## **SSD 8175 – WESTERN SYDNEY STADIUM (STAGE 2) - EIS**

## ATTACHMENT A

#### WESTERN SYDNEY STADIUM STAGE 2 – CONSTRUCTION AND OPERATION

$L_{max}$   
in dB(A)

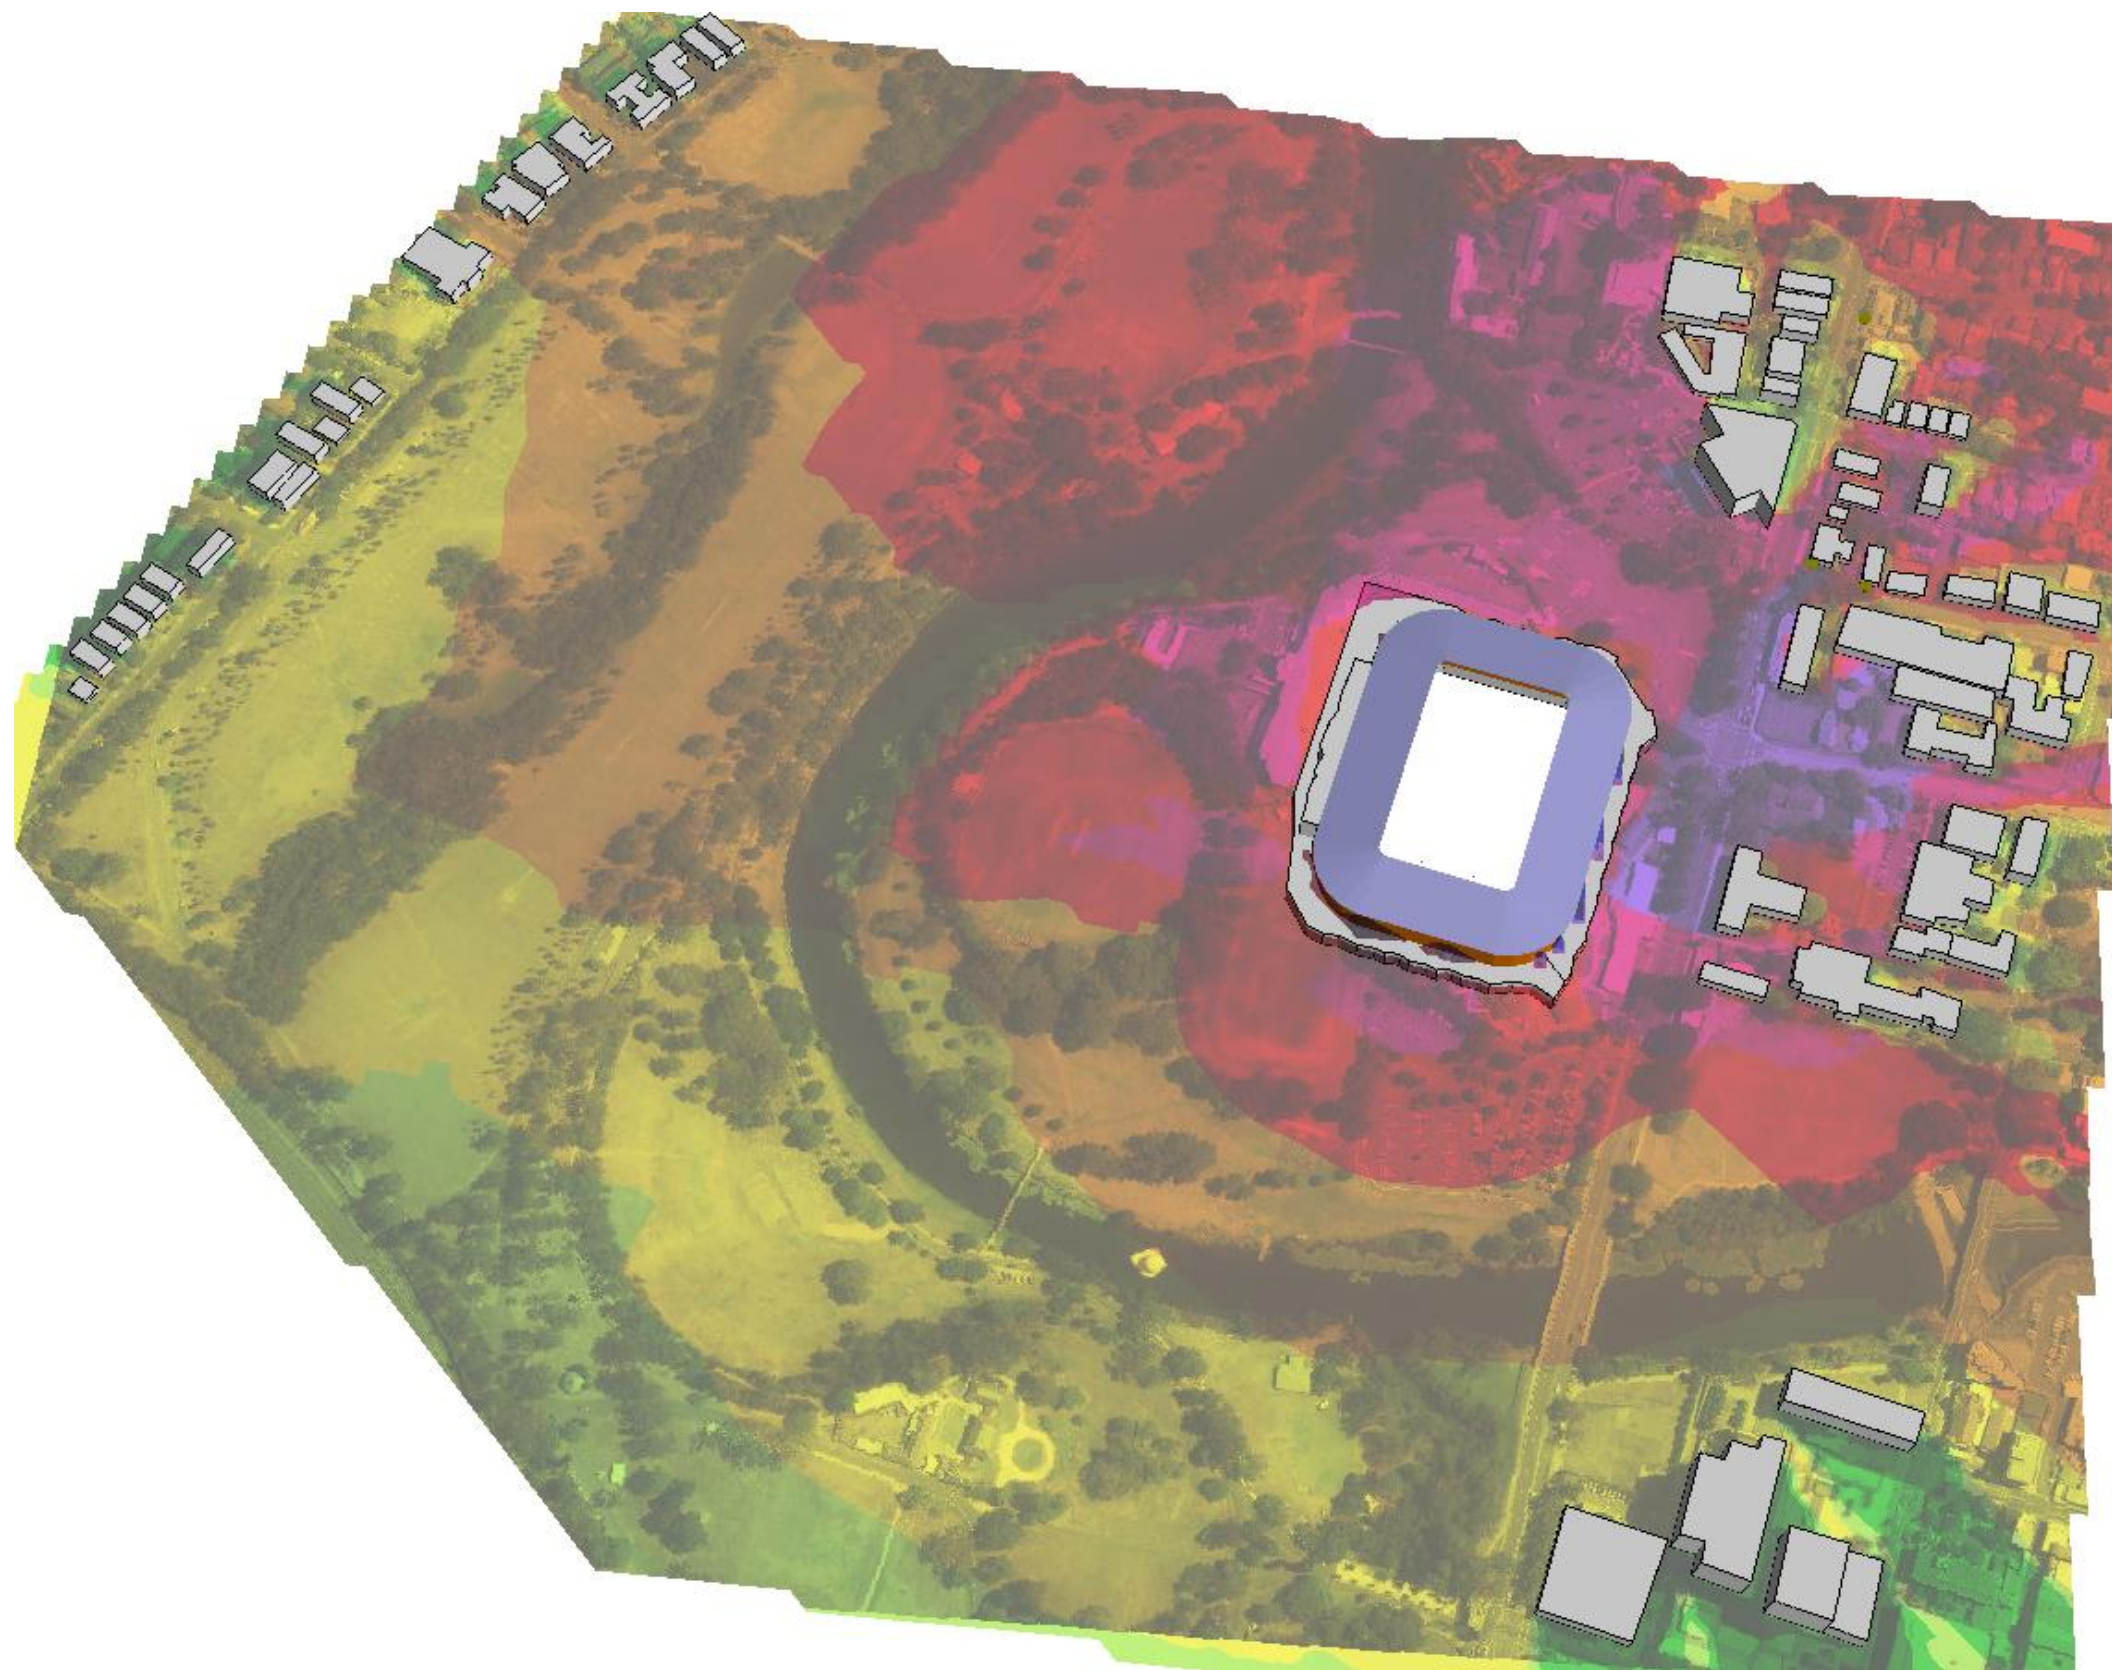
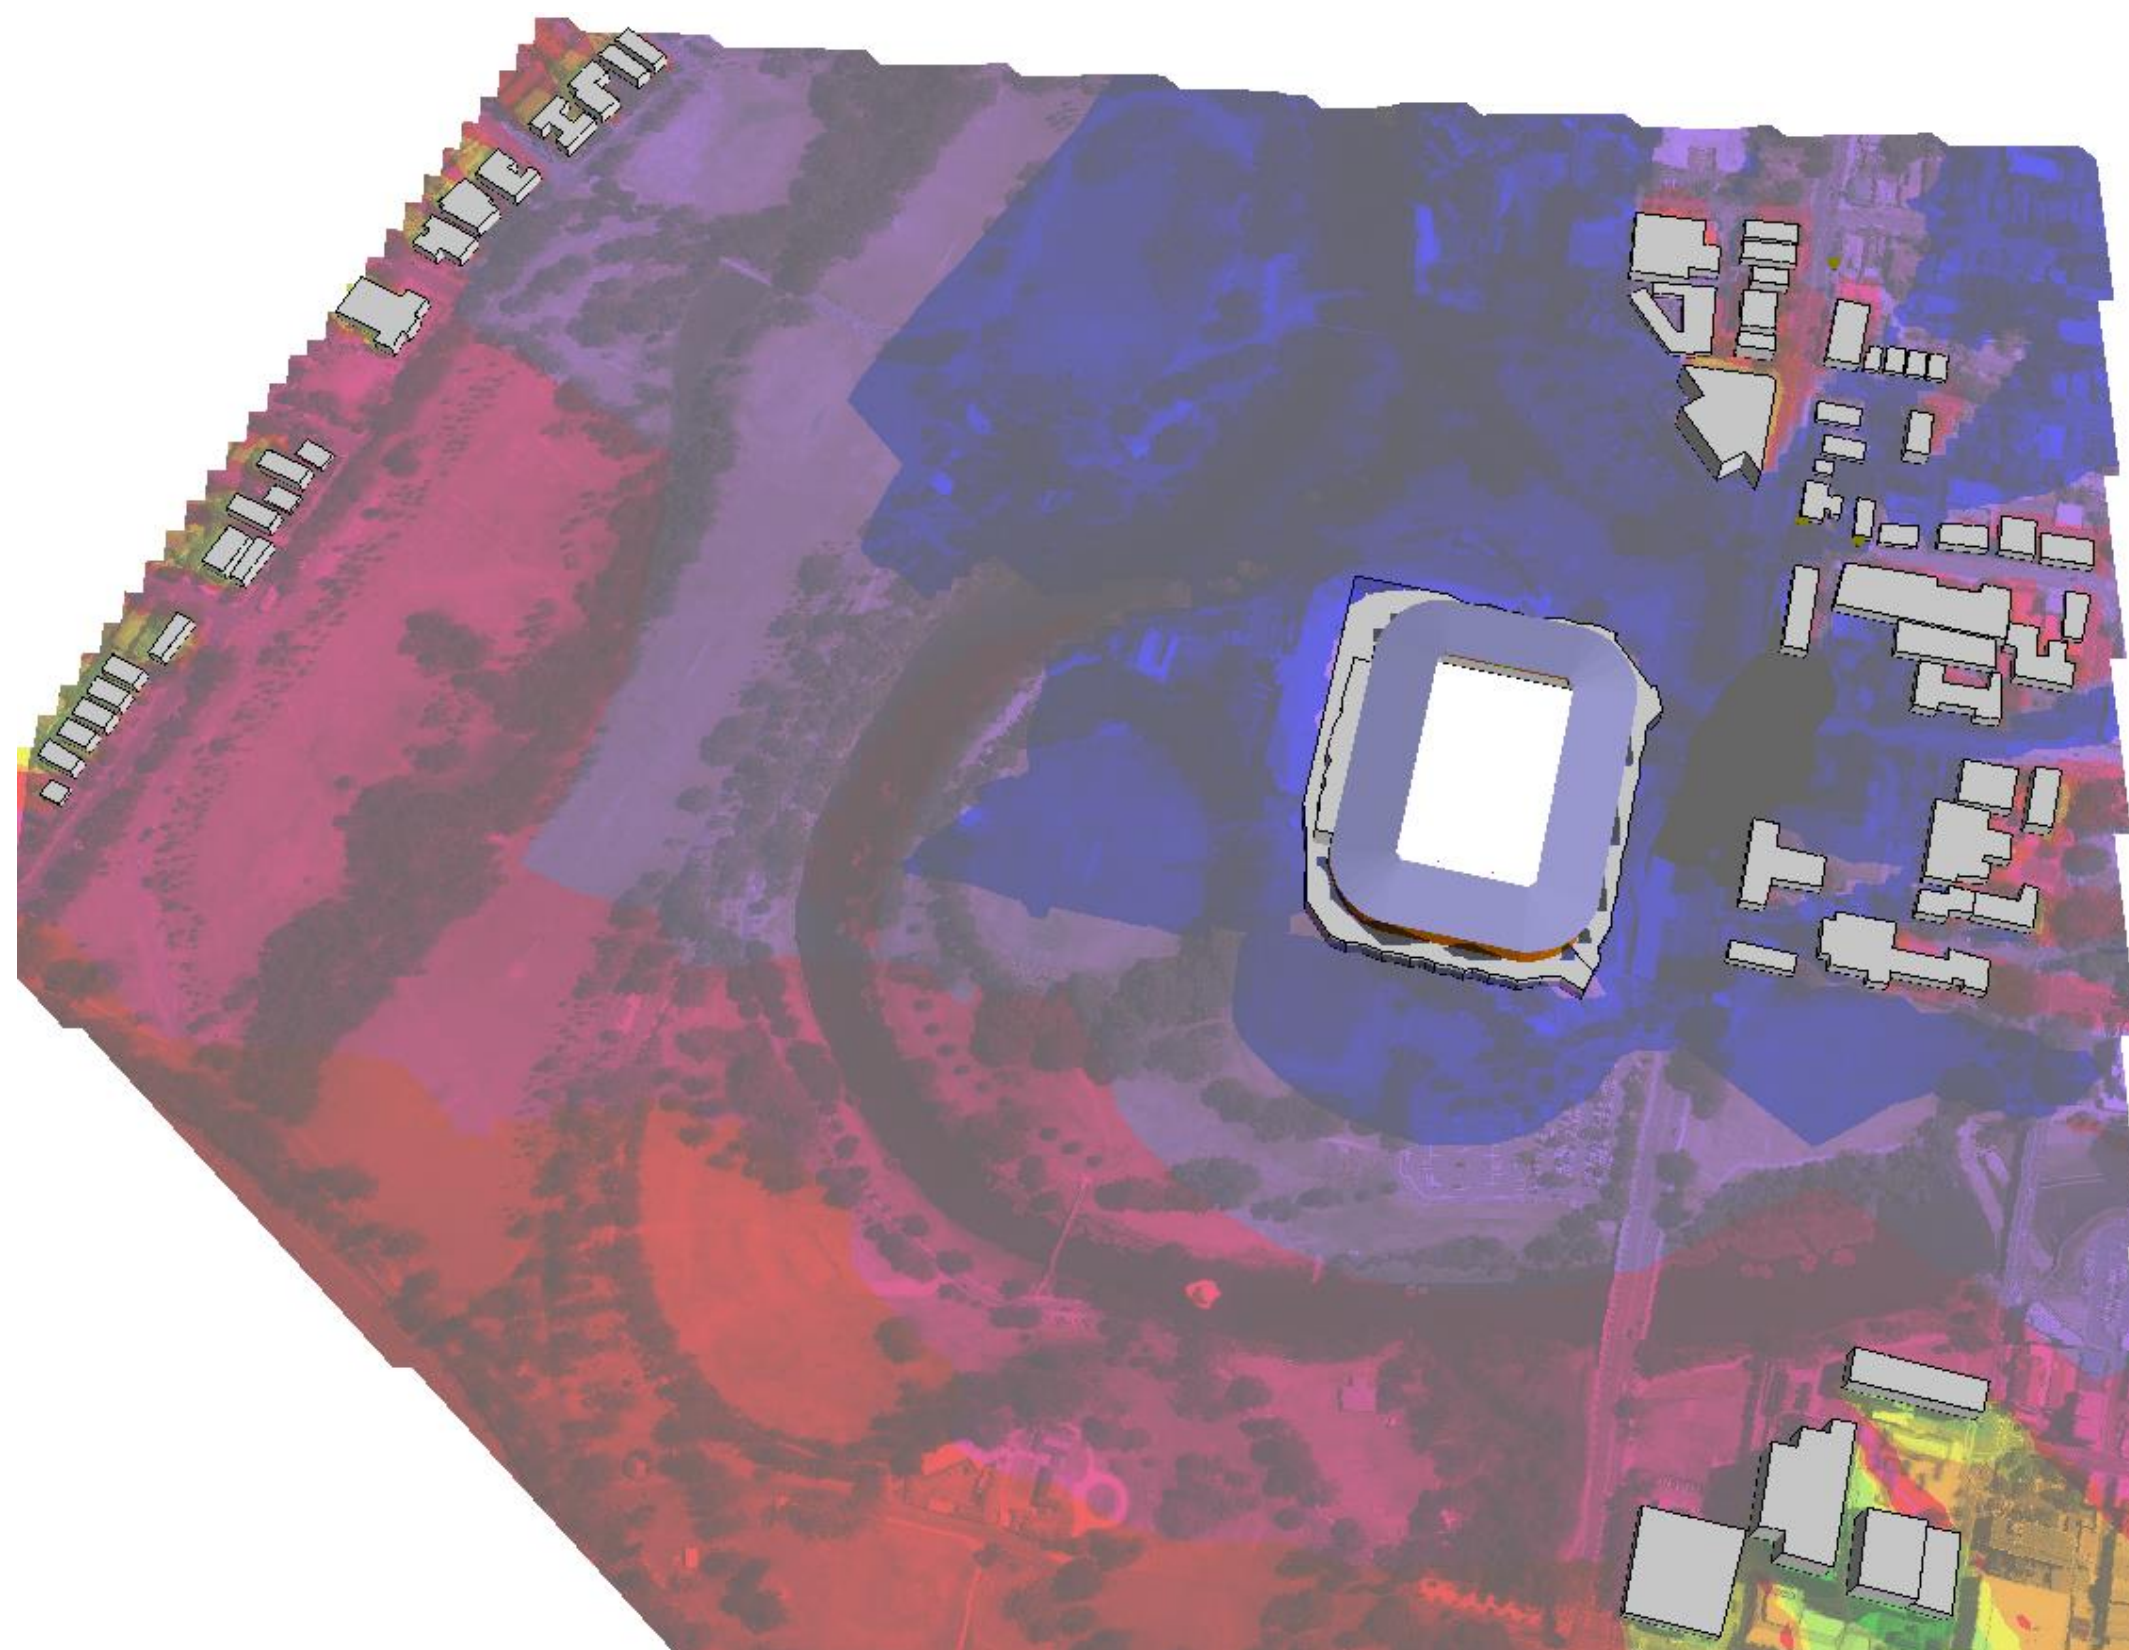
The EPA acknowledges that whilst predicted operational noise contours are presented (developed using proprietary noise modelling software), EIS Appendix S does not include –

- (a) tabulated data using the various recommended A and C weighted noise descriptors required to facilitate proper evaluation of those predicted noise impacts,
- (b) details of predicted day-time noise impacts on non-residential noise sensitive land uses.
